# SCOPING OPINION

## Proposed Perry's Farm Hazardous Waste Management Facility

January 2014

**PERRYS FARM**  
**SCOPING REPORT**  
**OUTLINE SITE LAYOUT**  
**PF 4**

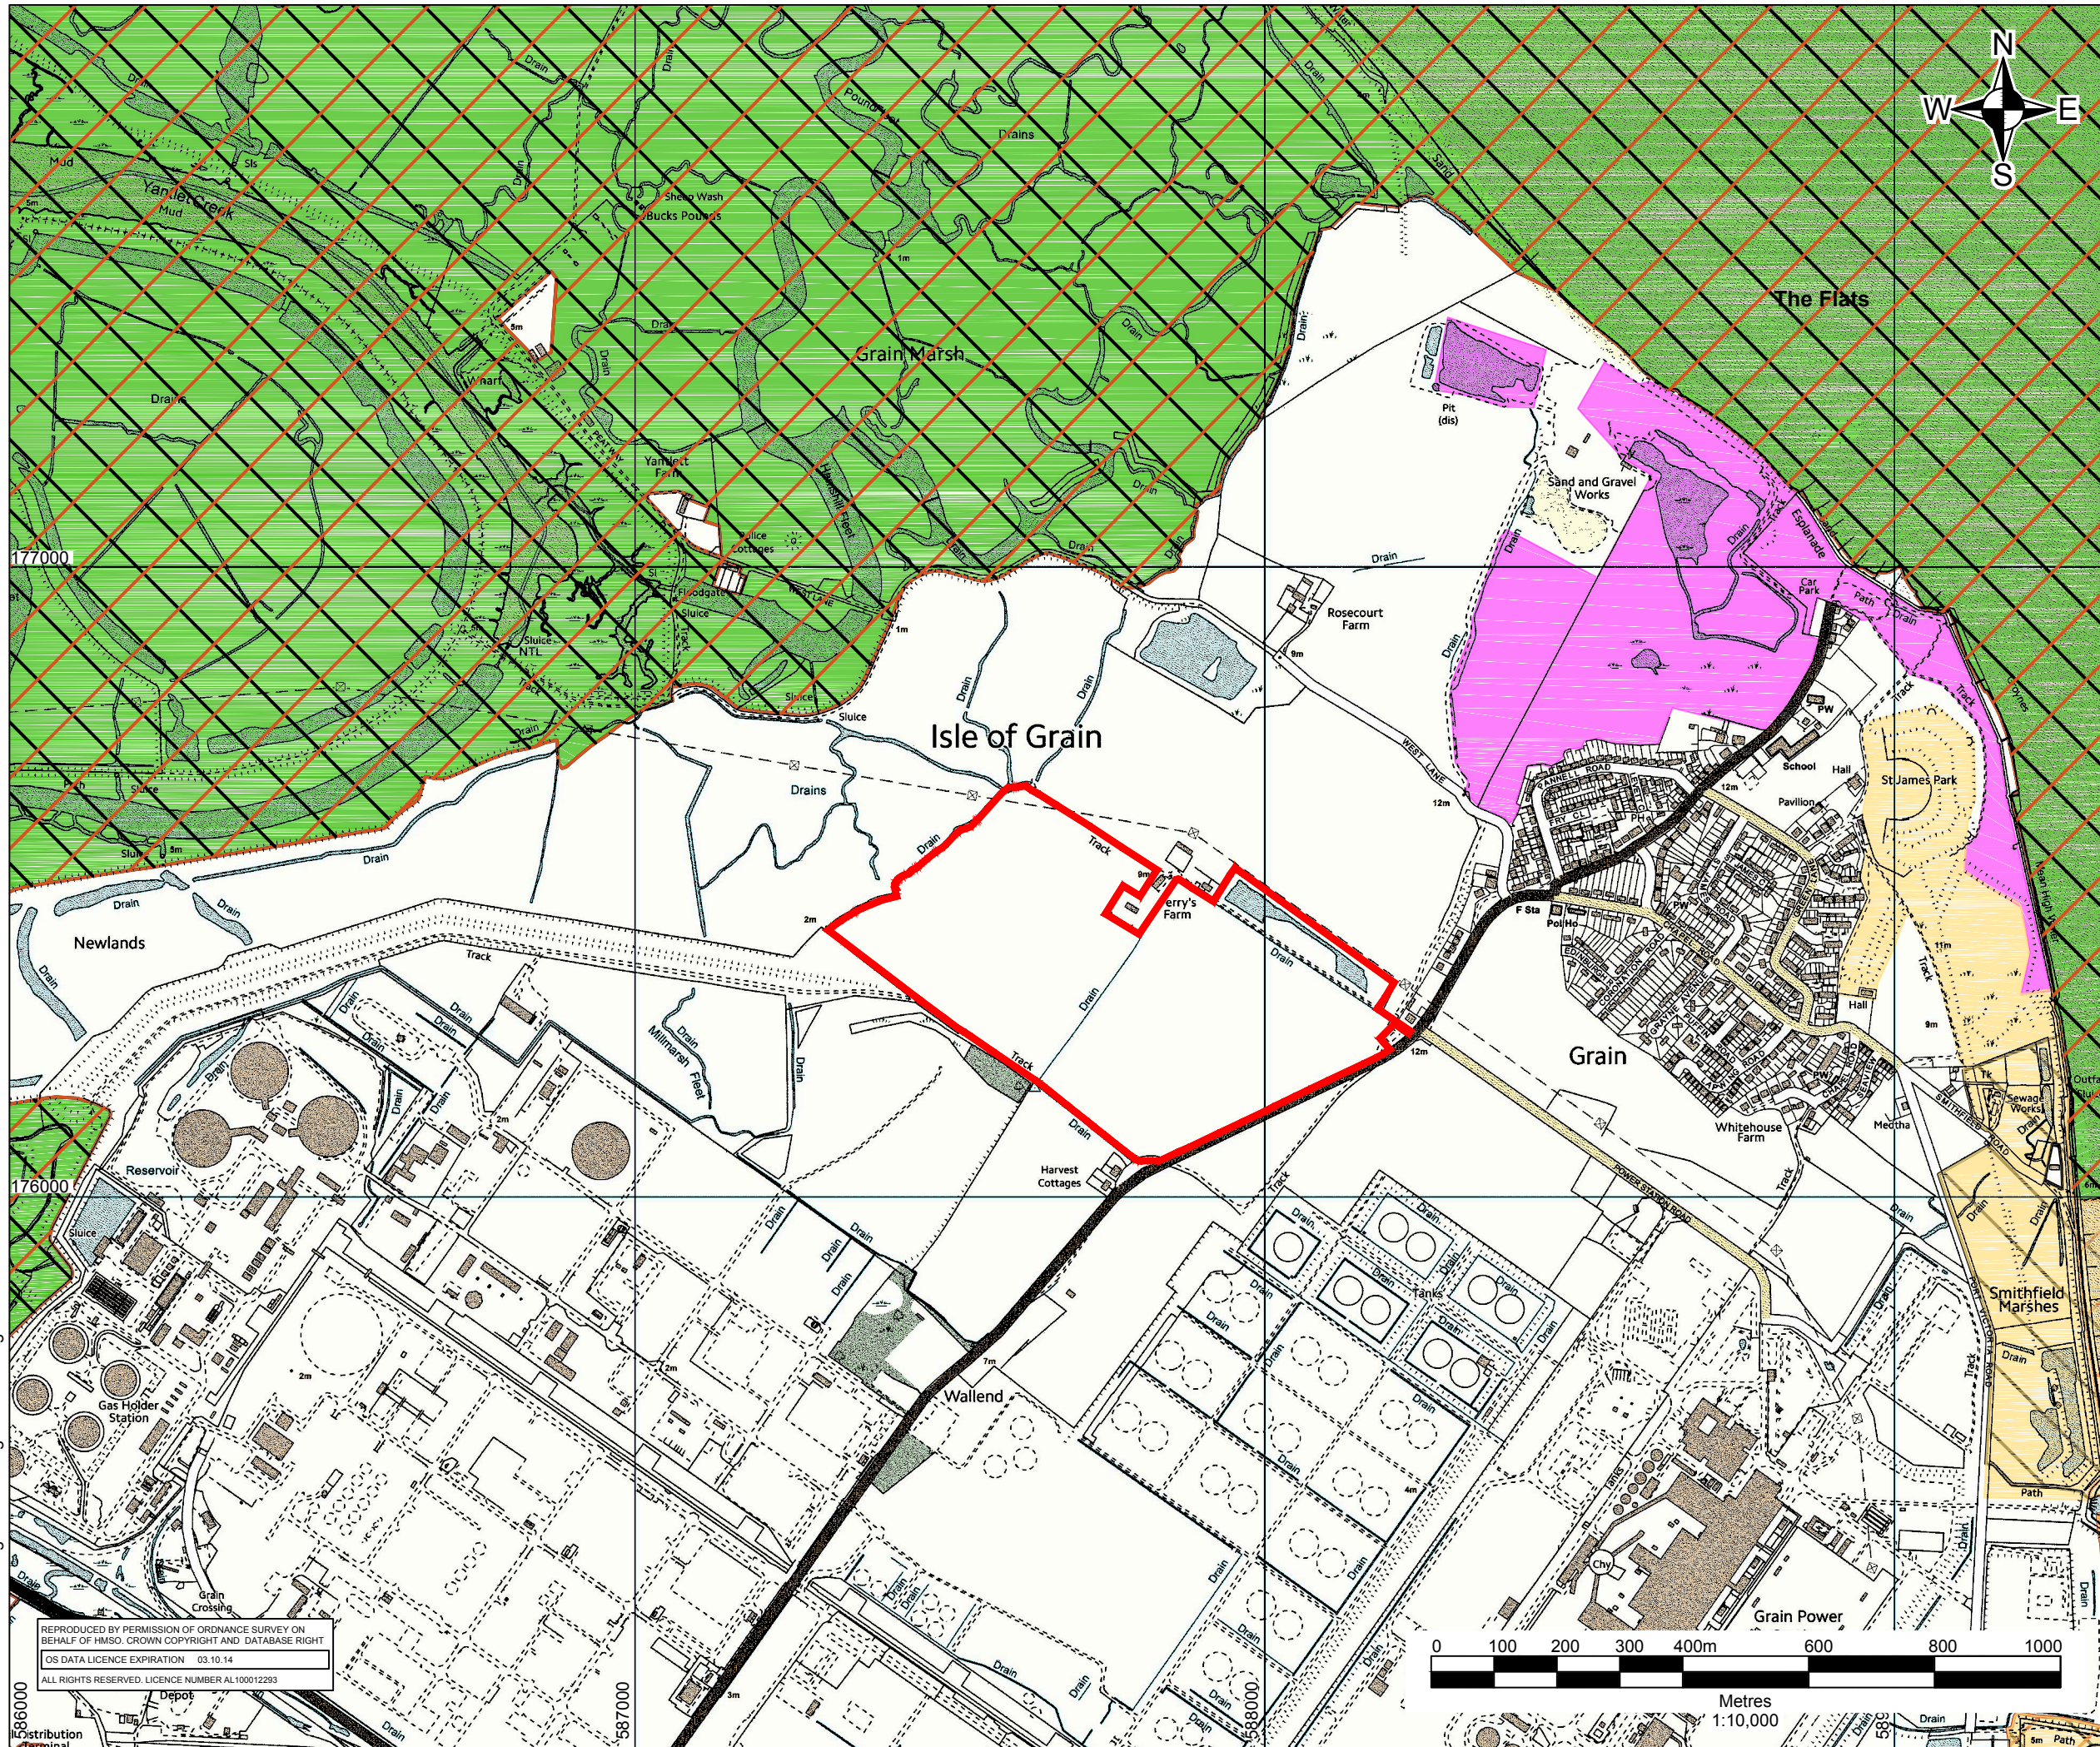
- 2.36 There are a number of land uses listed in Section 2.3 of the Scoping Report that do not appear on the Outline Site Layout Drawing (PF 4), and vice versa, land uses identified on the Drawing which are not listed as components of the development in Section 2.3. The applicant should ensure that there is consistency between the description of the development and all features described and illustrated within the main text and accompanying drawings. The SoS would welcome detailed land use plans to show the layout of the proposed development and the relationship between each component.

2.47 The SoS notes that an overview of the operational land use has been provided in Drawing PF 4. The SoS would expect to see a similar Drawing to illustrate the construction land uses, for example the size and location of construction compounds and material storage.
